ASHFIELD & DISTRICT HISTORICAL SOCIETY Inc

29 March 2013

**RE: MP10_0180 Stage 1 Project Application Summer Hill (former) Flour Mill – 2-32
Smith St, Summer Hill**

Drawing
DA1000

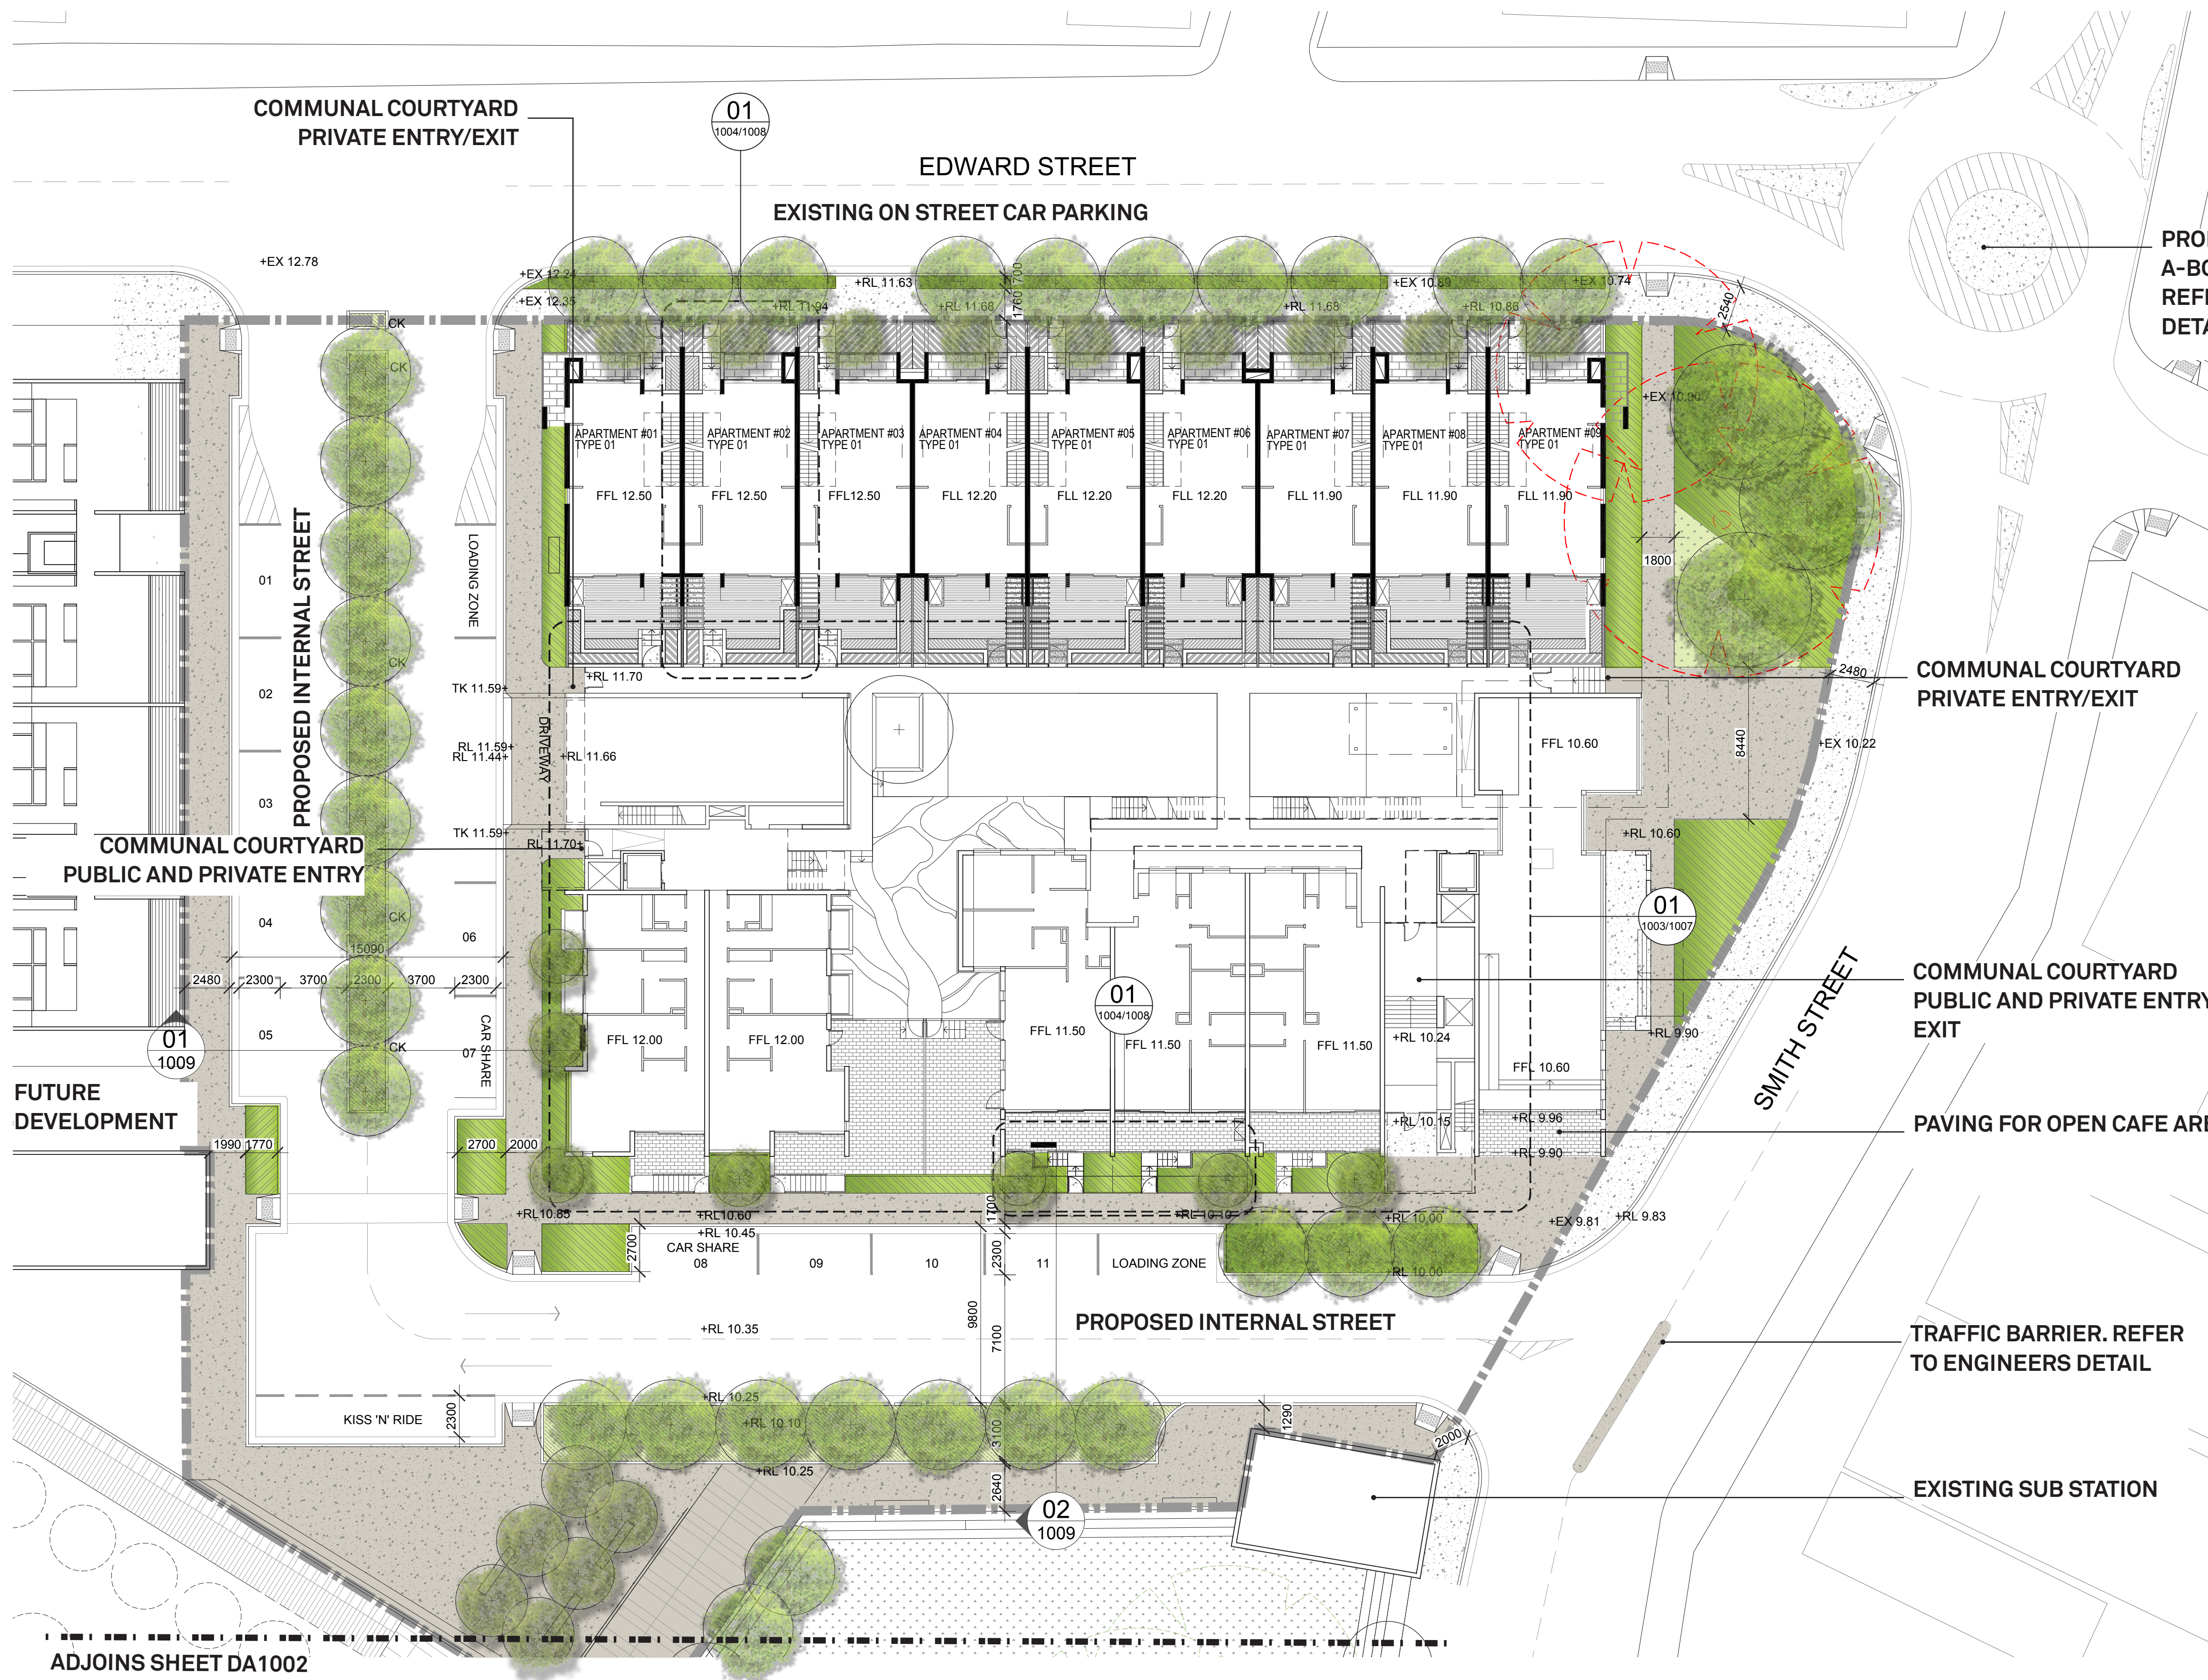
The Stage 1 Project Application plans however show the **removal** of these significant trees at the Smith Street corner with Edward Street, the justification apparently to be found in arborist Stuart Pettendrih's report.

Mr Pettendrigh rates these trees at low streetscape value and further he states they are not significant in the locality. These views are certainly **not** those of the AD&HS Committee (which includes members with relevant qualifications) nor myself as a resident of the immediate locality. Other residents I have spoken to are also surprised (and then annoyed) at Mr Pettendrigh's assessment.

Mr Pettendrigh does note in his report that his comments are based on a visual inspection of the tree() only, with no root investigations, drilling or sampling. He surmises that the roots are likely to be under the existing driveway and carpark (at the front of the existing former mill office building) and that '... (they) won't survive the (proposed) construction'. However the Concept Plan/PPP does **not** show any proposed development further north than the existing north –facing wall of this existing office building and, given that this building has an existing basement area and is separated from the trees by the width of a driveway and carpark, it is difficult to see how Mr Pettendrigh can arrive at his conclusion that the trees can be removed, certainly without any investigation.

The Concept Plan/PPP documents show that the Stage 1 Edward Street terrace as a terrace of **eight (8)** dwellings, with the northernmost end wall of the terrace aligning with the **southern** side of the existing Edward St driveway crossing (to the office carpark referred to above). This can be established by reference to the curvature of the Edward St boundary, which commences on the northern side of this driveway crossing. However, the Project Application shows this terrace as nine **(9)** dwellings – any encroachment to the north of the existing office building should not be permitted and the siting of the terrace (if it is to be approved at 9) relocated to extend further to the south along Edward St, which can be readily accommodated. This would preserve the status quo for the Smith/Edward St trees.

The correct approach in ADHS's view is for recognised protective measures to be taken for these Smith/Edward Street trees during the construction phase (including excavation), as commonly applies (including when dealing with the retention of trees) by conditions of consent. If there has been a northern encroachment of the terrace by the Stage 1 plans this should be corrected, in furtherance of the protection of these trees.
